The views of the **Arun District Conservation Area Advisory Panel** are as follows:

Application No: BR/252/21/PL

Site Address: 65-71 Upper Bognor Road Bognor Regis PO21 1HR

Description of Works: Alterations to four listed buildings involving insertion of new windows, insertion of a new staircase, repairs and reinforcement of existing timber floors and roofs, removal of internal walls, forming openings in existing internal walls, erection of new internal partitions; extension of a listed building to create an office and warden's accommodation; erection of new building consisting of 3 No. flats, offices and workshops; creation of new private gardens, separation of this part of the site from the wider University campus, creation of a shared landscaped courtyard, creation of areas for parking and storage for bins and cycles. This application affects the setting of listed buildings, affects the character & appearance of the Upper Bognor Road & Mead Lane Conservation Area and is in CIL Zone 4 (Zero Rated) as flats & other development.

Upper Bogmor Road Residential Redevelopment Bognor Regis	
Drawing 67 & 69 Upper Bognor Road Ground Floor Proposed	
Scale @ A3 1:50	Drawing no. 5557-101-D2

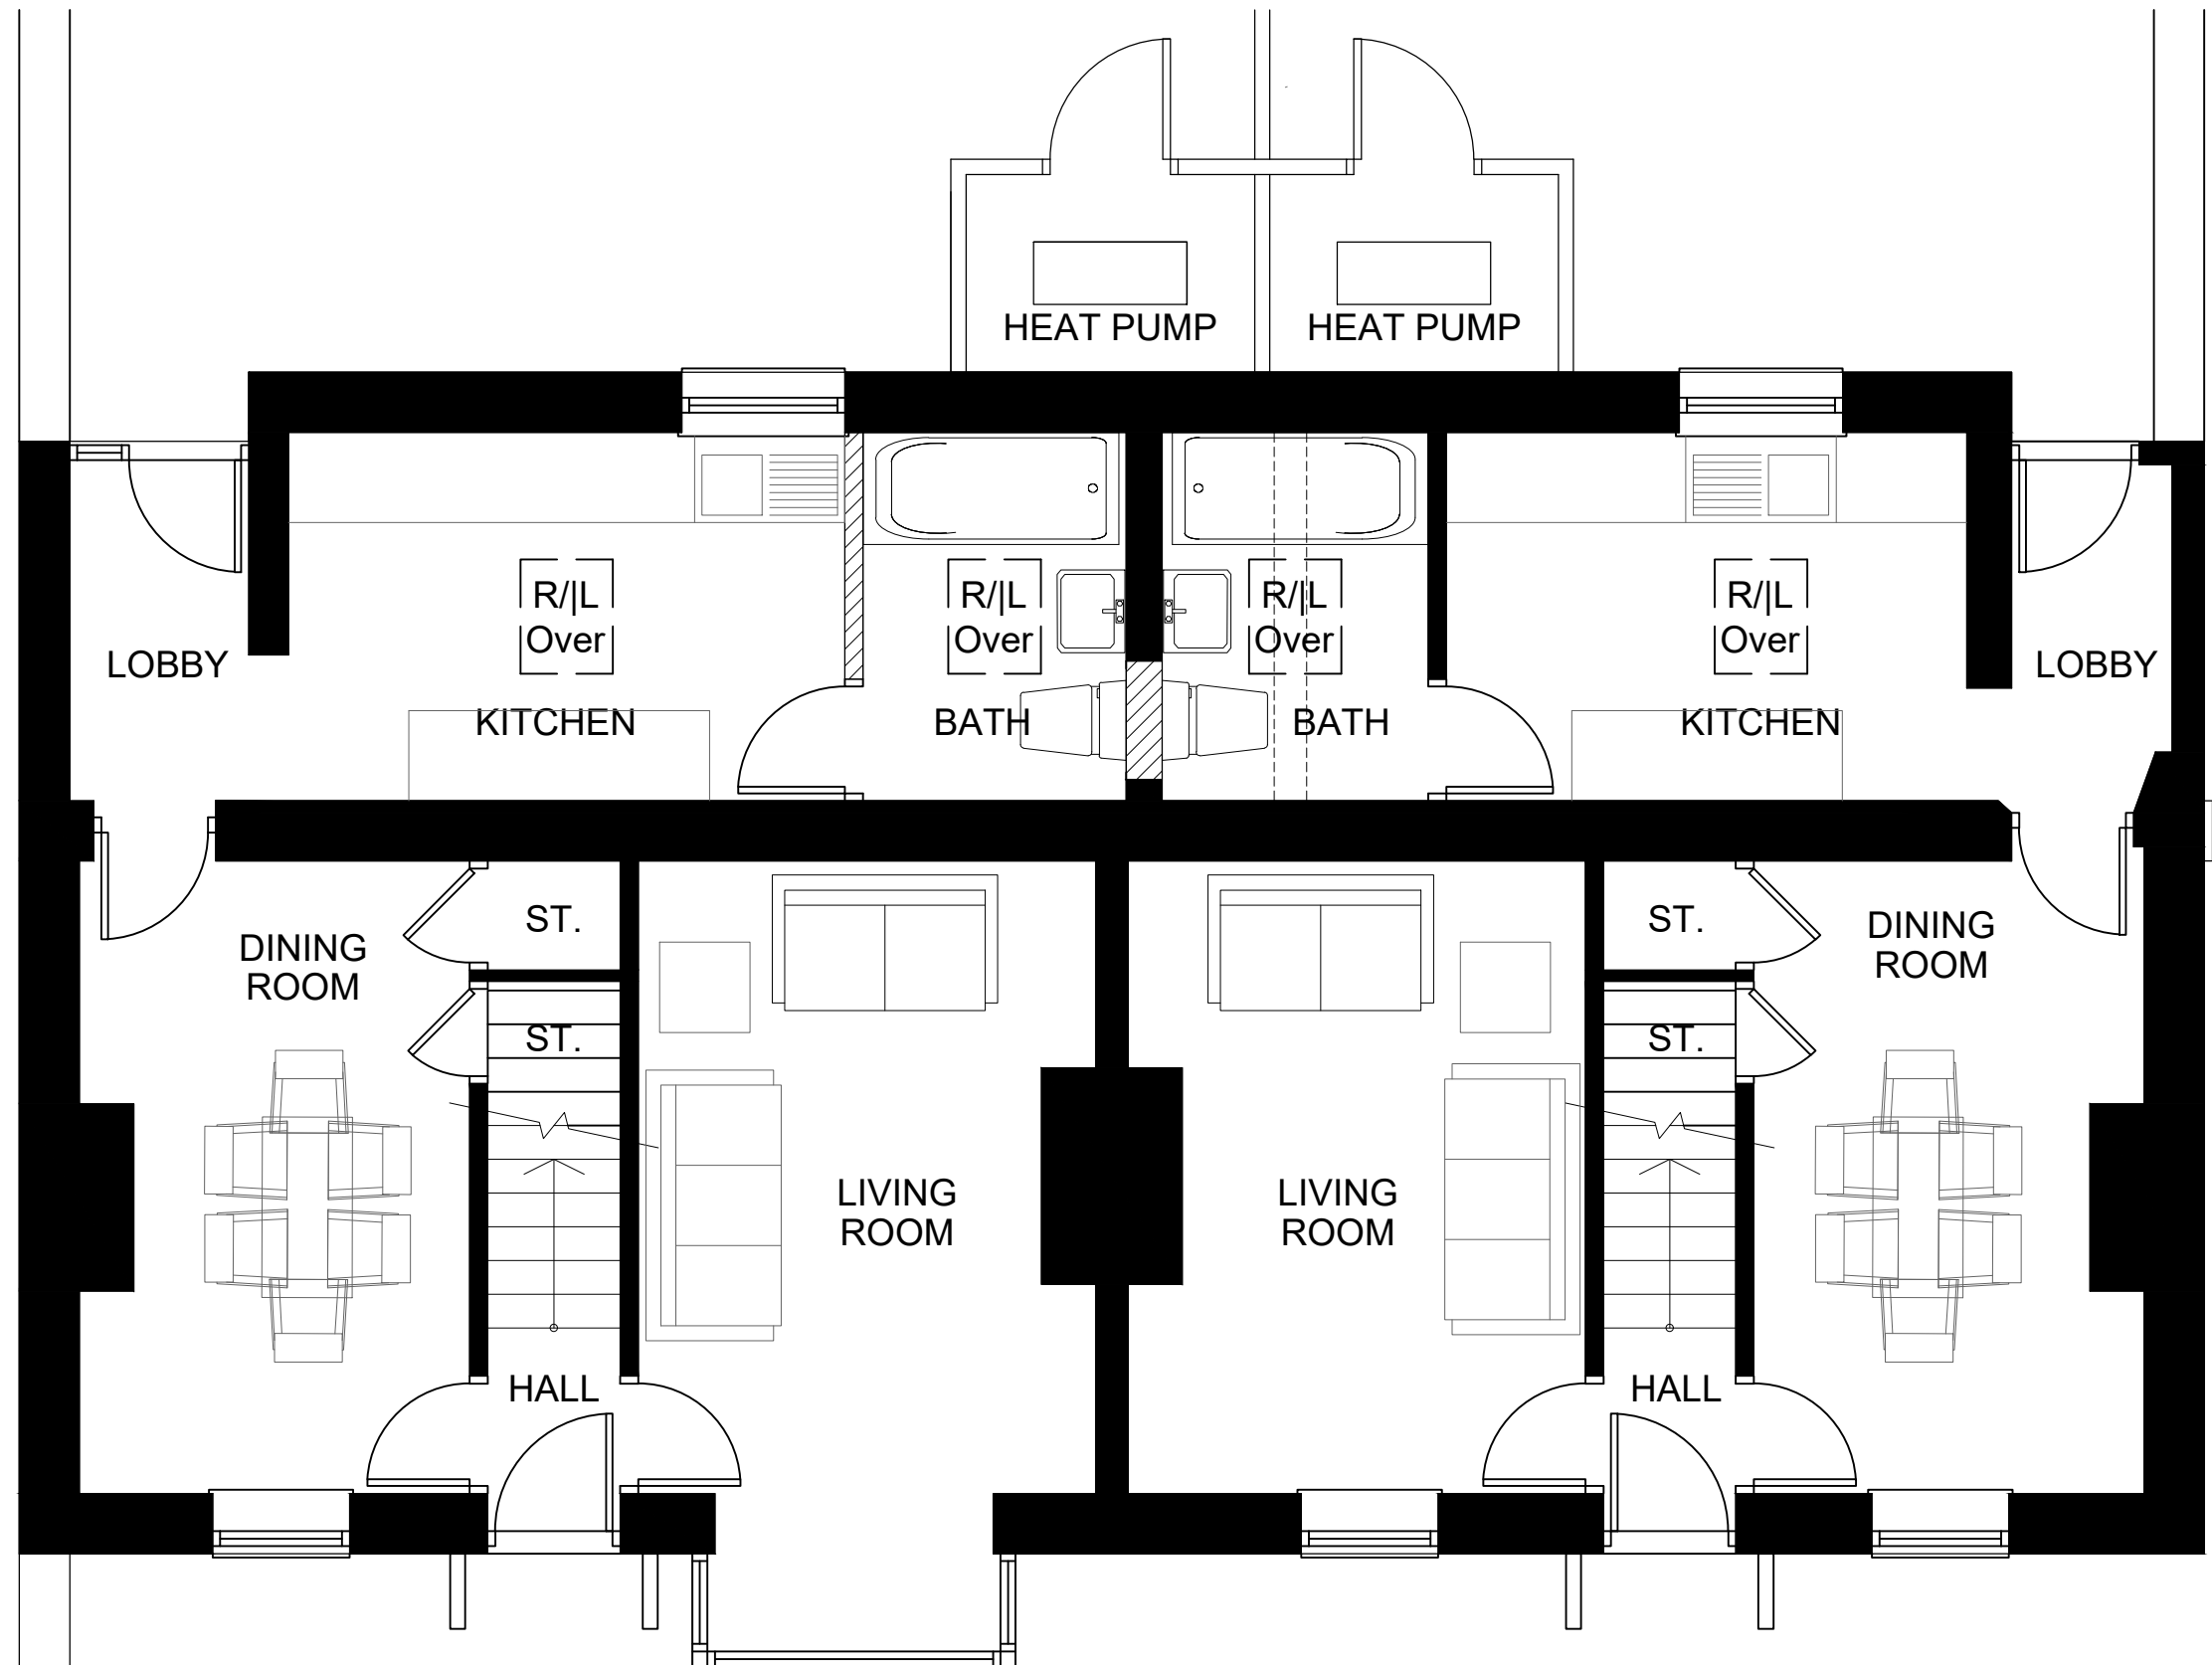
The Panel would suggest though that conservation roof lights should be used where roof lights are shown on the plans. In respect of any new or replacement windows relating to the listed buildings or extensions to them then precise details of fenestration needs to be submitted to ensure that the new windows are of an appropriate design in every way for historic buildings. Samples of the new natural slates also need to be submitted for agreement.
